**Your Ref:** OWPC21470  
**Our Ref:** FP/27/19/HH 05-02-2019  
**Please ask for:**  
Amber Willard

Single storey rear extension, re-siting of boundary wall & new vehicular access.

29 Blackthorn Avenue Felpham

PROPOSED BOUNDARY WALL AND VEHICULAR ACCESS AT 29, BLACKTHORN AVE., FELPHAM
FOR MR. & MRS. A. CONNOR.

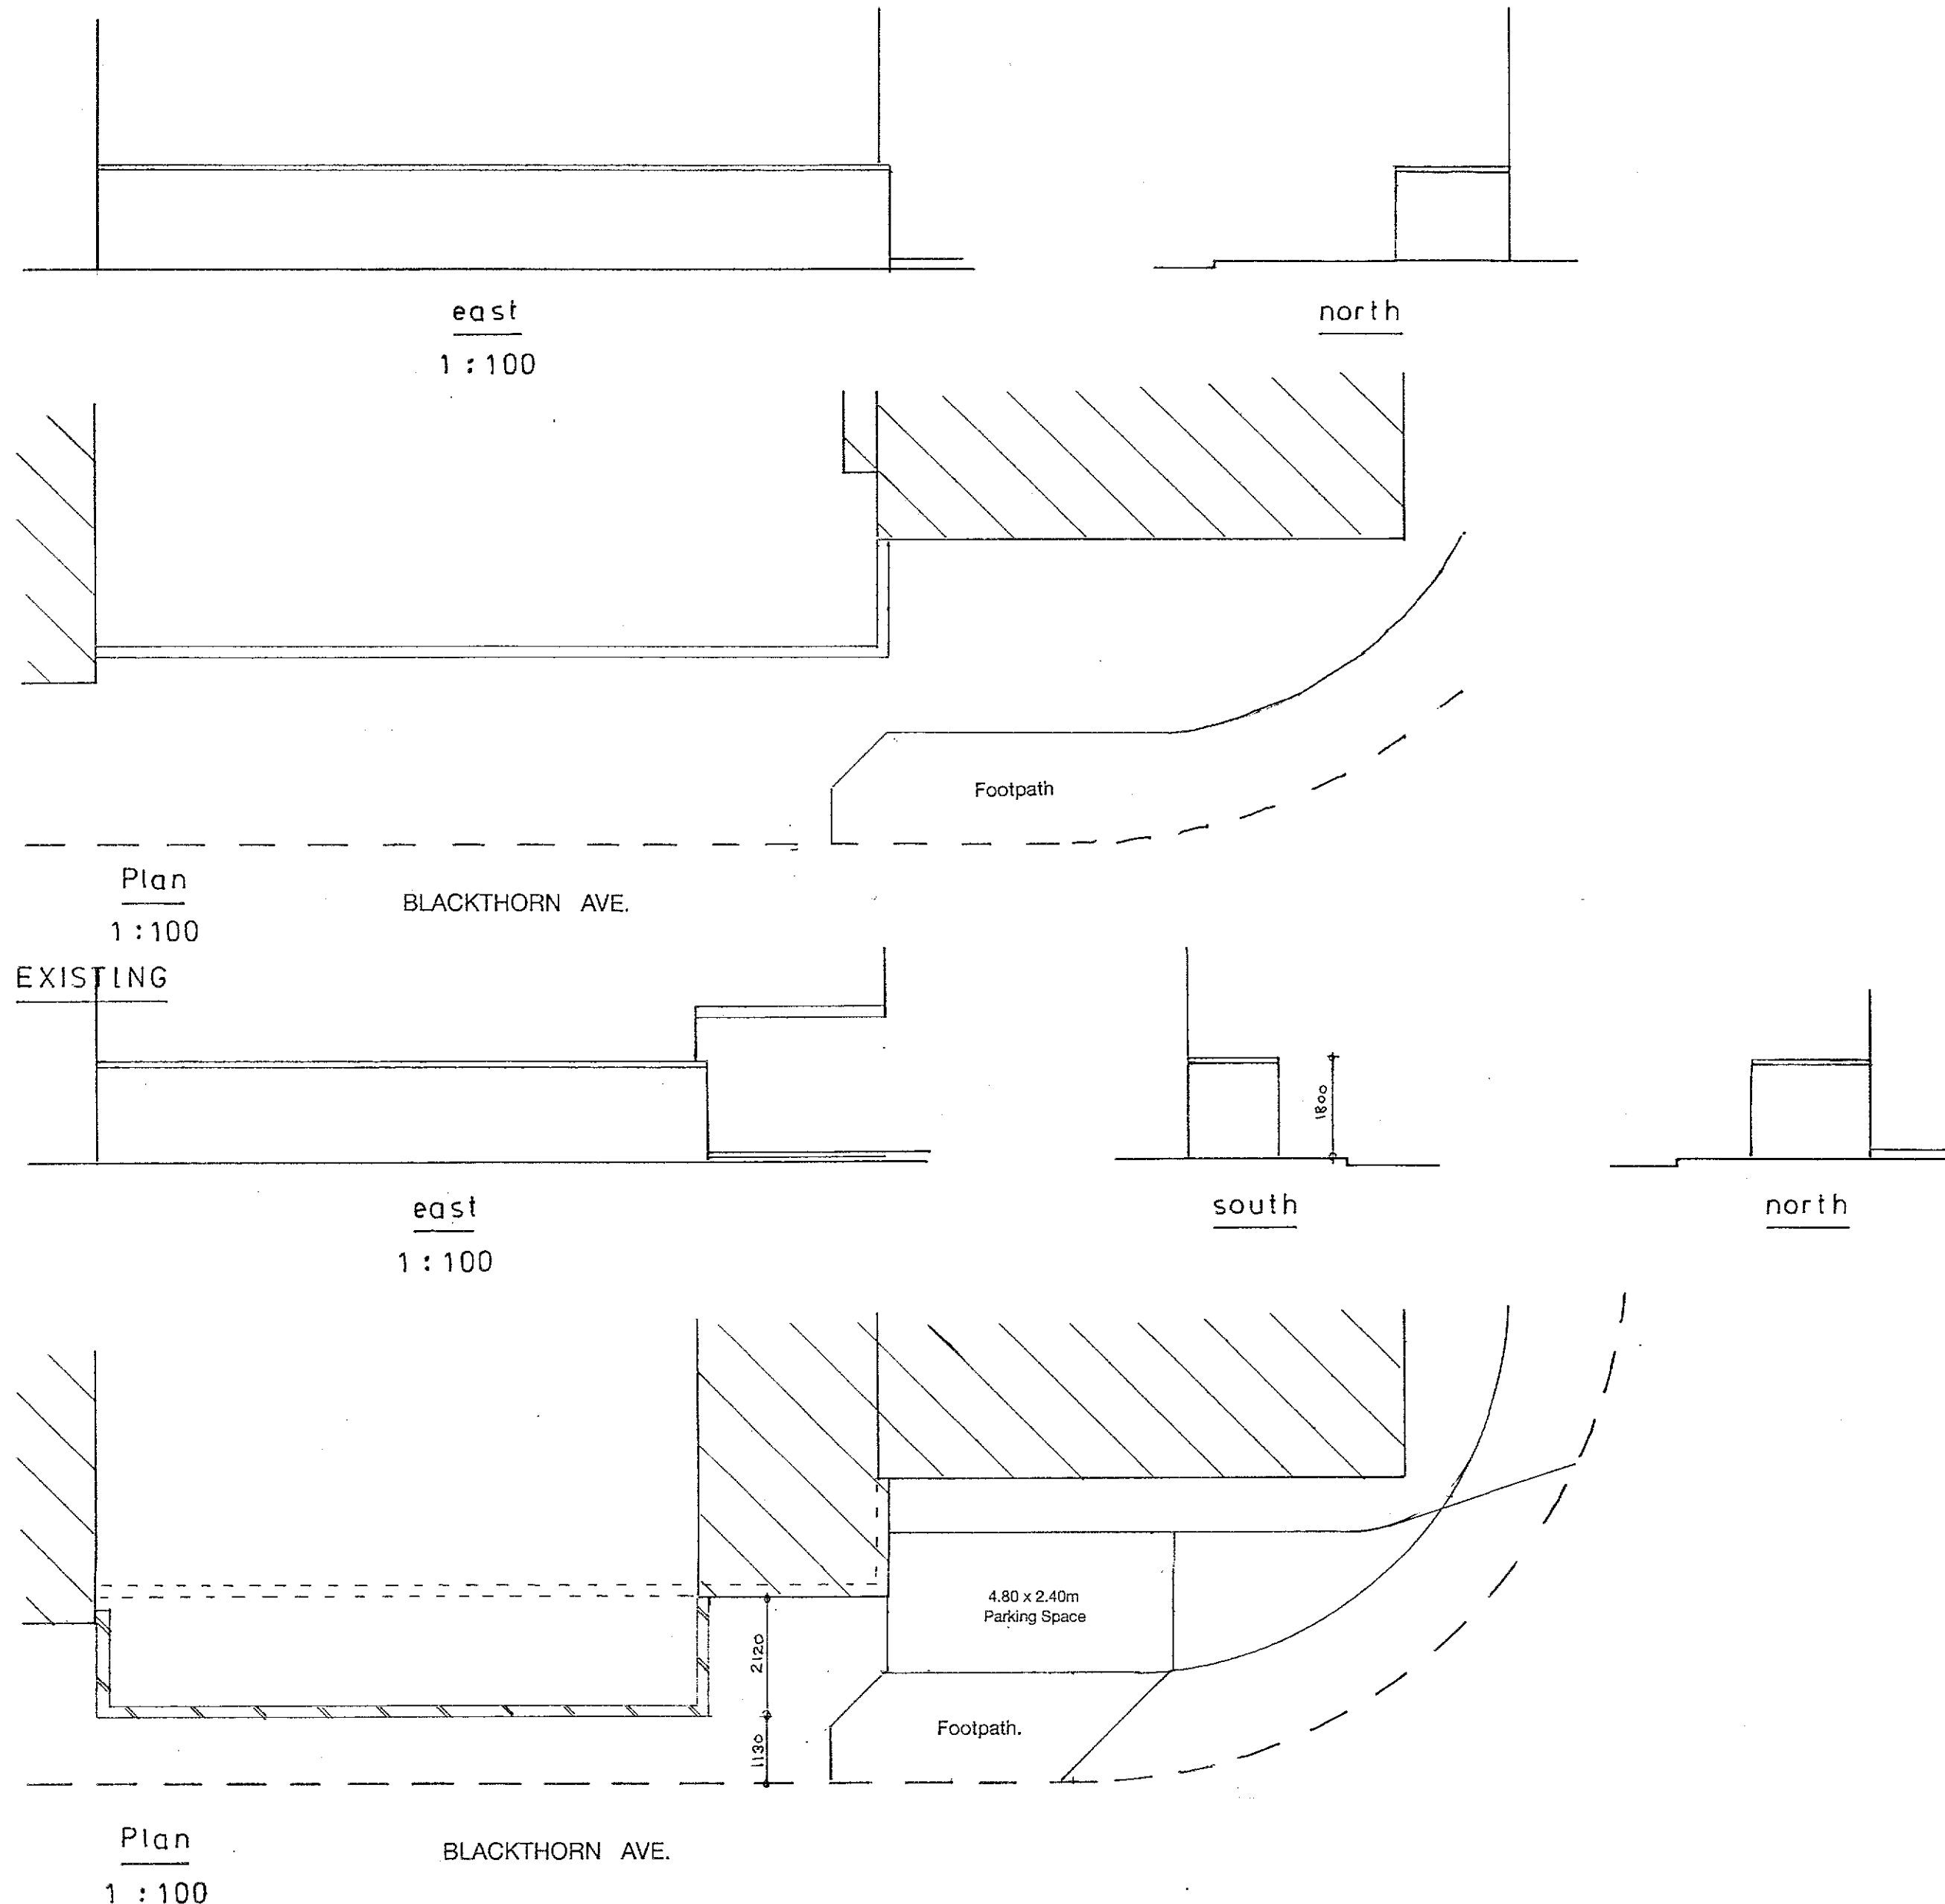
*My main objection to this extension is that moving out the side wall will cause a serious visual obstruction for vehicles exiting the garage block at the back of this house, which I and 3 other houses have access to. Access in and out is already tricky due the parked vehicles and adding a solid wall/house extension will block any ability to see vehicles coming round a blind corner. I am also concerned that a vehicle will be exiting a parking space on a blind corner and across the only side of the road with a pavement. There was a drop curb near that corner which I understood was removed for that reason, so don't understand how this would be acceptable. Thank you for your consideration.*
